Application for a non-material amendment following a grant of planning permission.

Number	8
Suffix	
Property name	
Address line 1	Church Lane
Address line 2	
Address line 3	
Town/city	Pagham
Postcode	PO21 4NS
Description of site location must be completed if postcode is not known:	
Easting (x)	488509
Northing (y)	97532

Reference number: P/119/20/HH

A change of doors to new window and matching brick, flint and pebble wall infill arrangement on the Front Elevation Proposed.

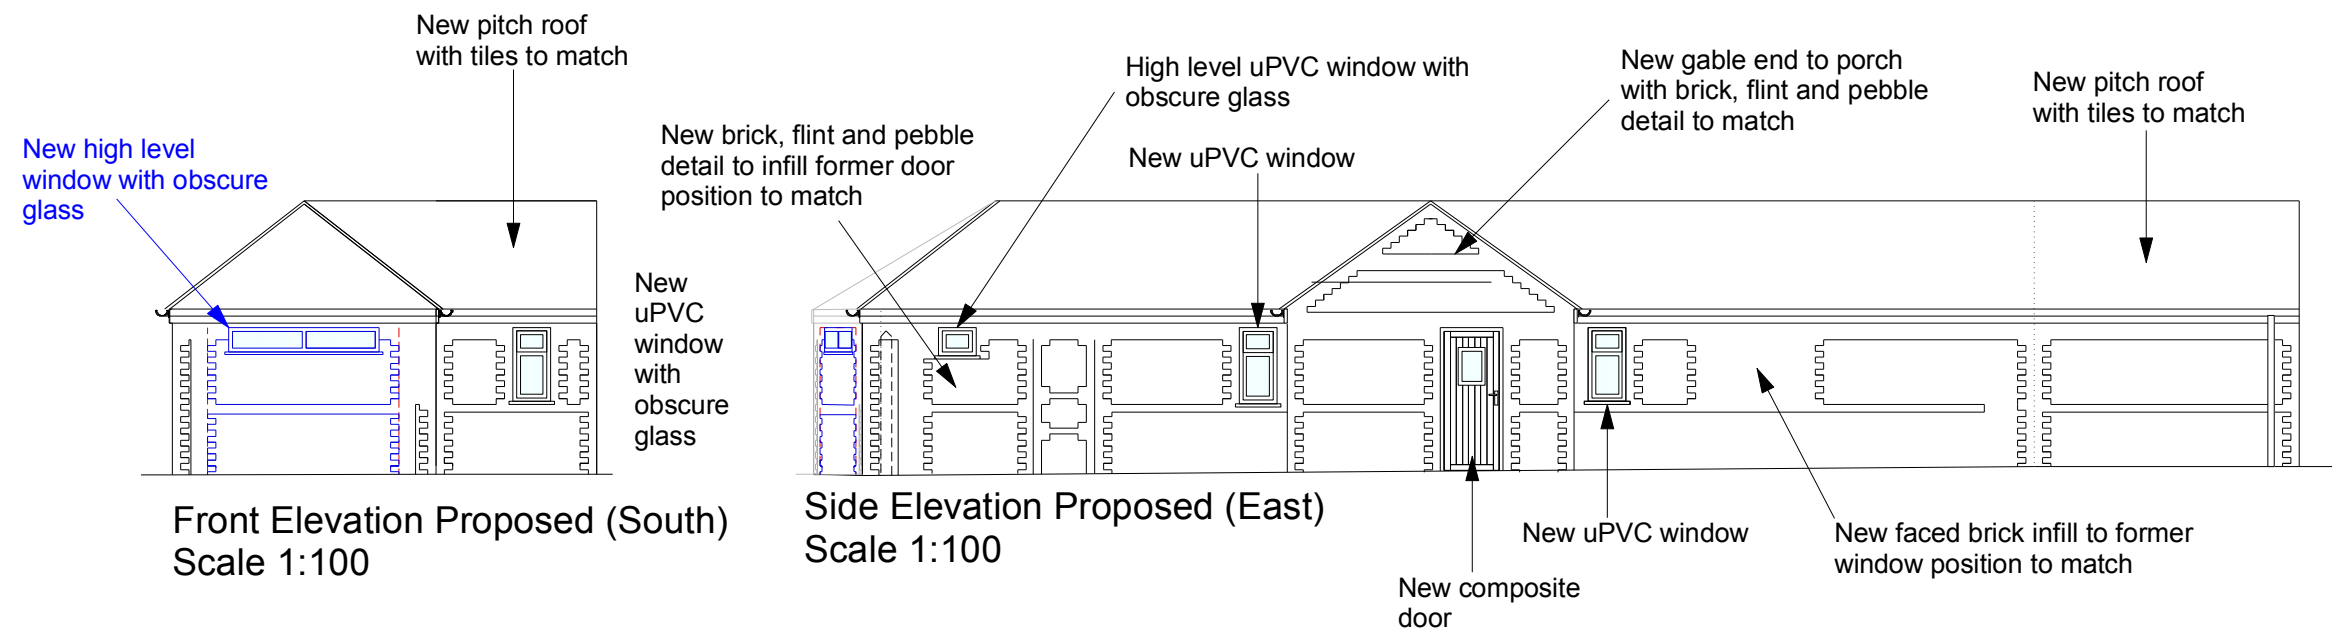
Due to the proposed internal room reconfiguration (F,F & E) and to improve natural daylight into the room.
